City of Portland, Maine - Building or Use Permit Application
 389 Congress Street, 04101 Tel: (207) 874-8703, Fax: (207) 874-8716

Permit No: 03-1482	Issue Date:	CBL: 057 K017001
------------------------------	--------------------	----------------------------

Location of Construction: 11 Salem St	Owner Name: Connemara Development Llc	Owner Address: 10 Meadow Way	Phone: 207-939-6126
Business Name: n/a	Contractor Name: Connemara Development LLC	Contractor Address: 10 Meadow Way So. Portland	Phone: 2079396126
Lessee/Buyer's Name: n/a	Phone: n/a	Permit Type: Duplex	Zone:

Dept: Zoning	Status: Approved with Conditions	Reviewer: Marge Schmuckal	Approval Date: 01/14/2004
Note: 12/11/03 I gave back to Karen - no minor site plan is in the system even tho it was paid for - also no scaleable site plan included in the packet. 12/30/03 received scaleable plans 1/12/04 After last Wed site plan meeting, it was confirmed by R. K. that I do need the heights of the adjoining buildings in order to determine setbacks. I left a message for Peter Coyne 1/13/04 Peter Coyne brought in info I needed

**LEFT ELEVATION**

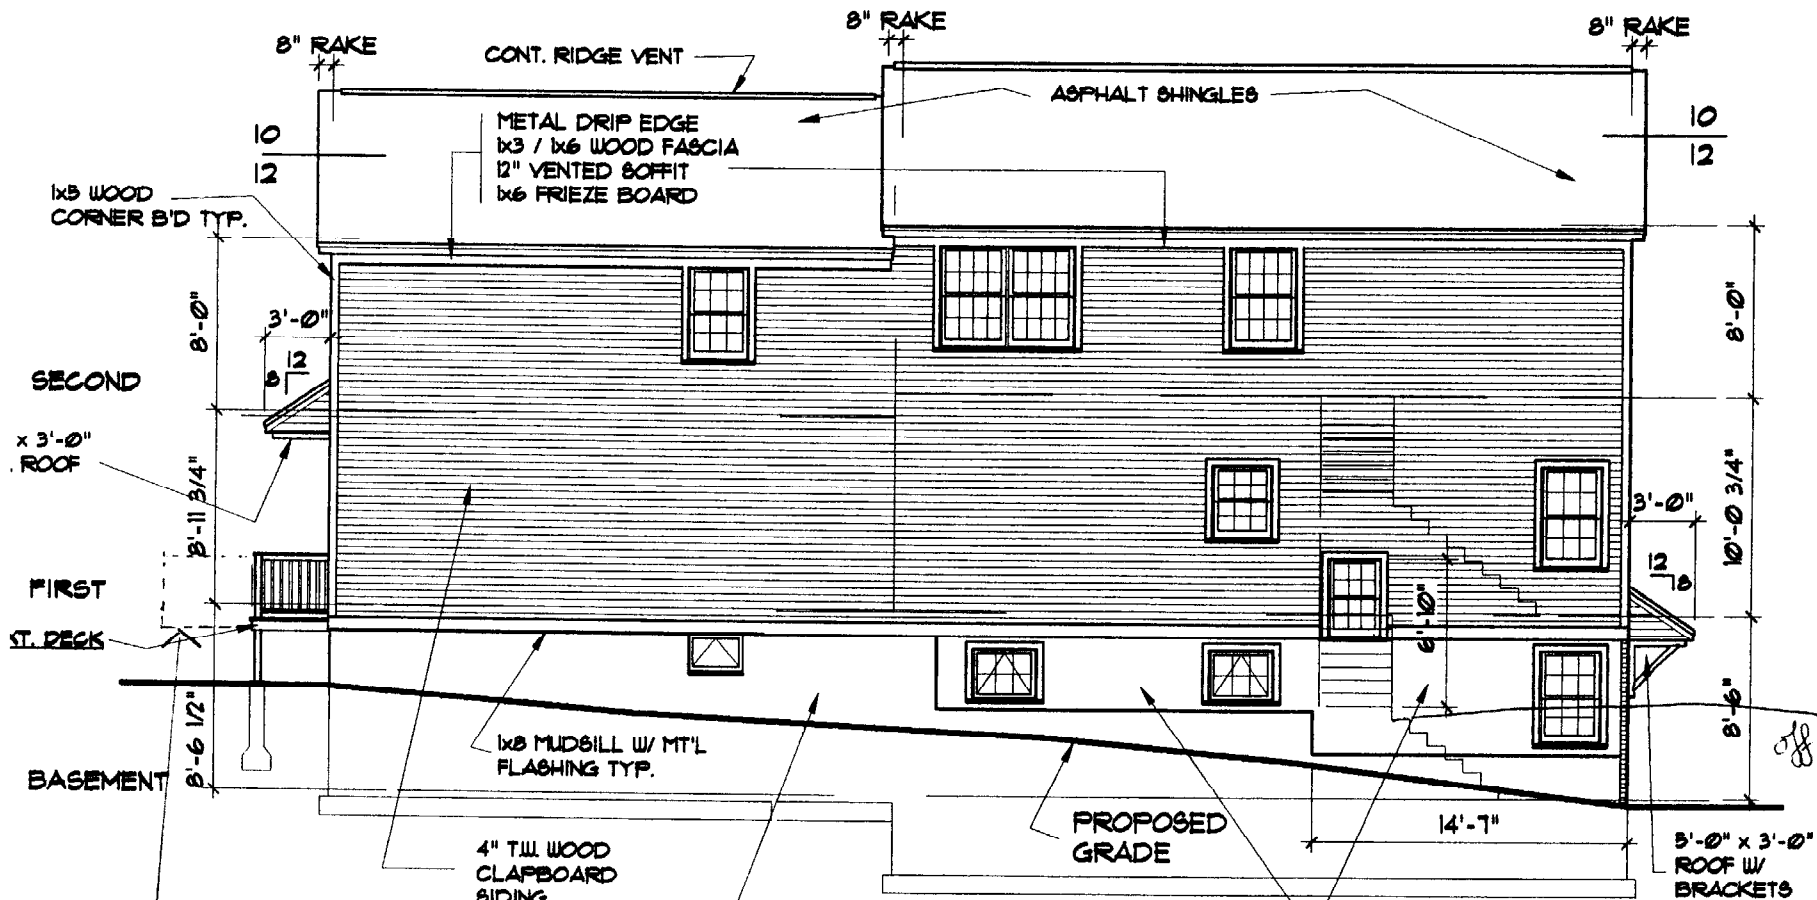
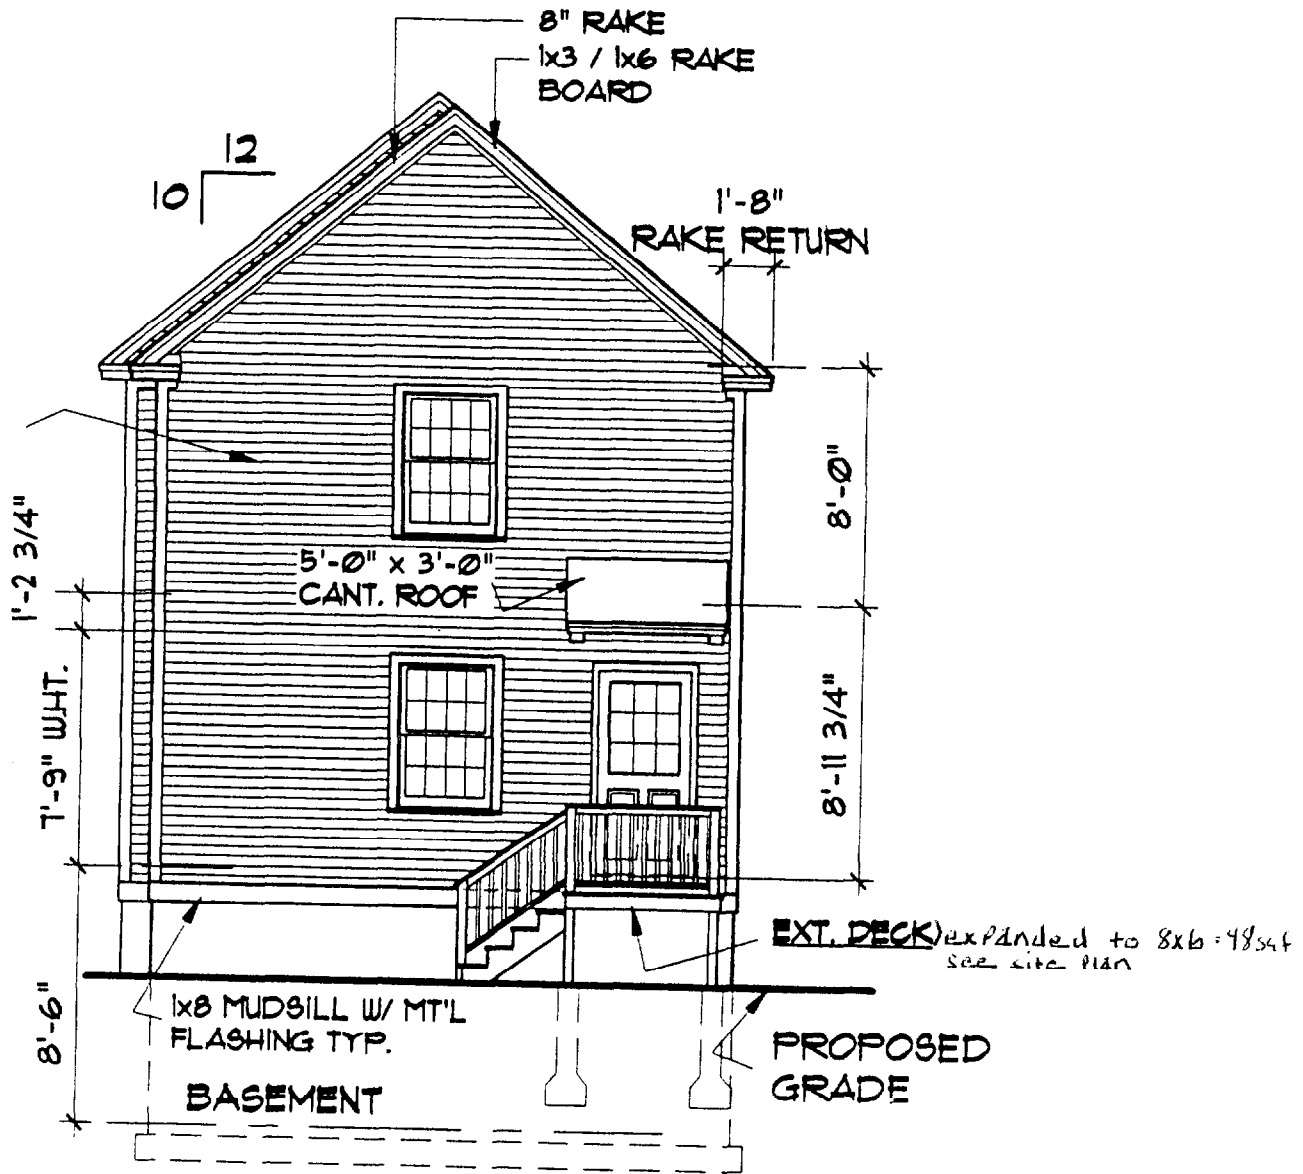
1) Separate permits shall be required for future decks, sheds, pools, and/or garages. On the submitted plans a rear deck 6' x 8' is being shown.			
2) This property shall remain a two (2) family dwelling. Any change of use shall require a separate permit application for review and approval.
